Our Ref: 068535_CUR_CO_D_0001

Great Wolf Lodge – LLFA Objection Response

Following your recent comments on the supporting documents of application 19/02550/F, relating to flood management and drainage, please see the below responses.

**Figure 5-1: QBar Calculation**

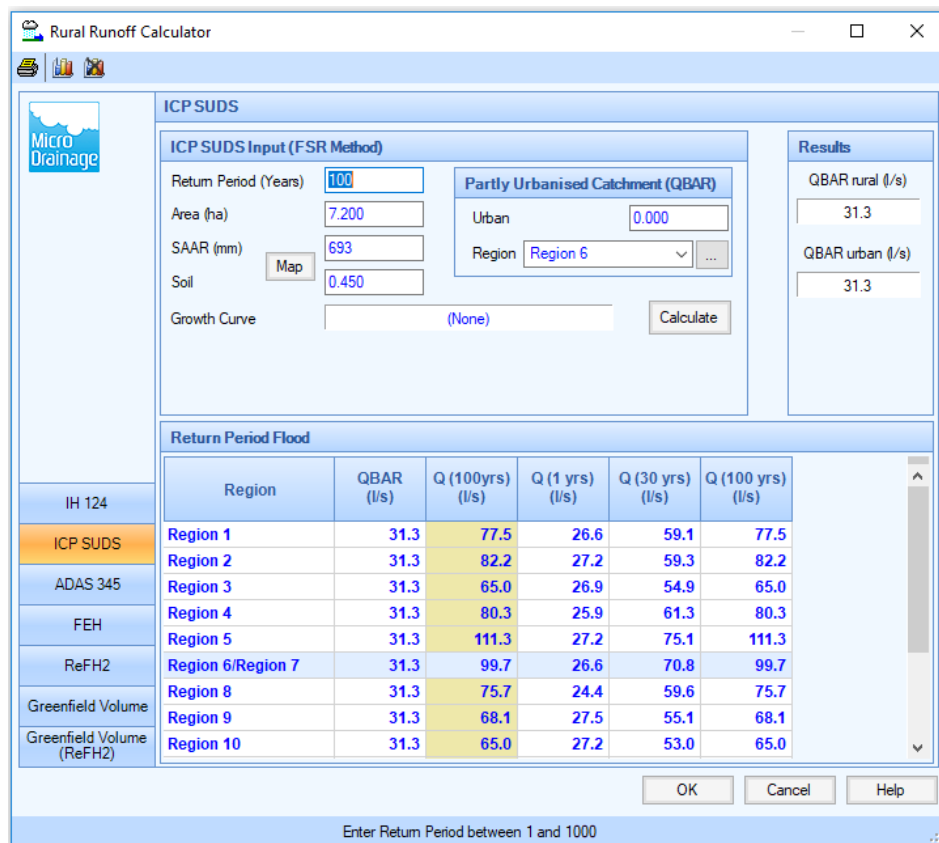
Section 5.2.2. identifies the use of Qbar methodology. For a site this size FEH should be used, (Qmed).

The use of QBAR for the site discharge rate was confirmed by Richard Bennett from the LLFA via email on 22nd July 2019. The email is appended to this response as evidence.

Figure 3-3: UAV Groundwater Survey

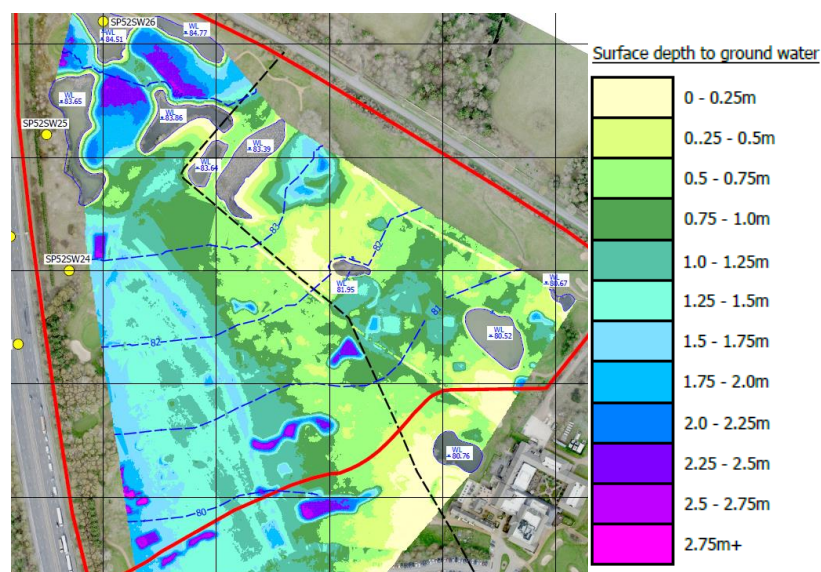
Borehole/BRE to determine level of ground water to be provided.

No intrusive surveys are able to be conducted due to the golf course remaining live until planning is granted. Unmanned Aerial Vehicle surveys of the site have demonstrated the groundwater levels. These will be confirmed post planning.

Figure 4-3: Surface Water Discharge Route

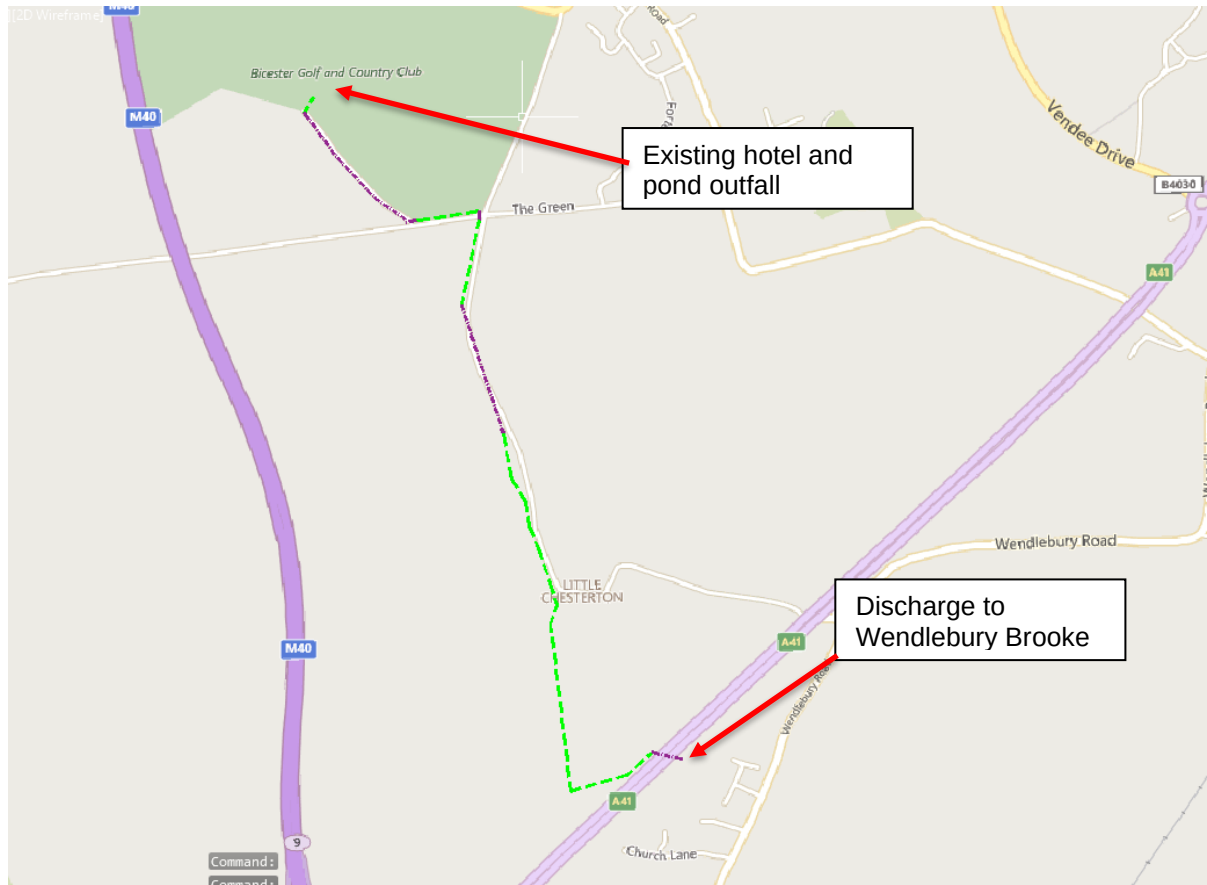
Discharge noted to be to Gagle Brook ordinary watercourse. Riparian ownership and consent to discharge to be justified. Ditch condition and capacity to take additional flows to be demonstrated.

Discharge via ditched to Wendlebury Brook. Discharge to be in third party land to the south of the proposed site. Written permission to be demonstrated by the owner of Bicester Golf Resort and Spa. The existing back nine holes of the golf course are drained using a network of land drains, to the proposed outfall. As the proposed peak site discharge is to be at QBAR, the ditch should see no increase in peak discharge from the site.
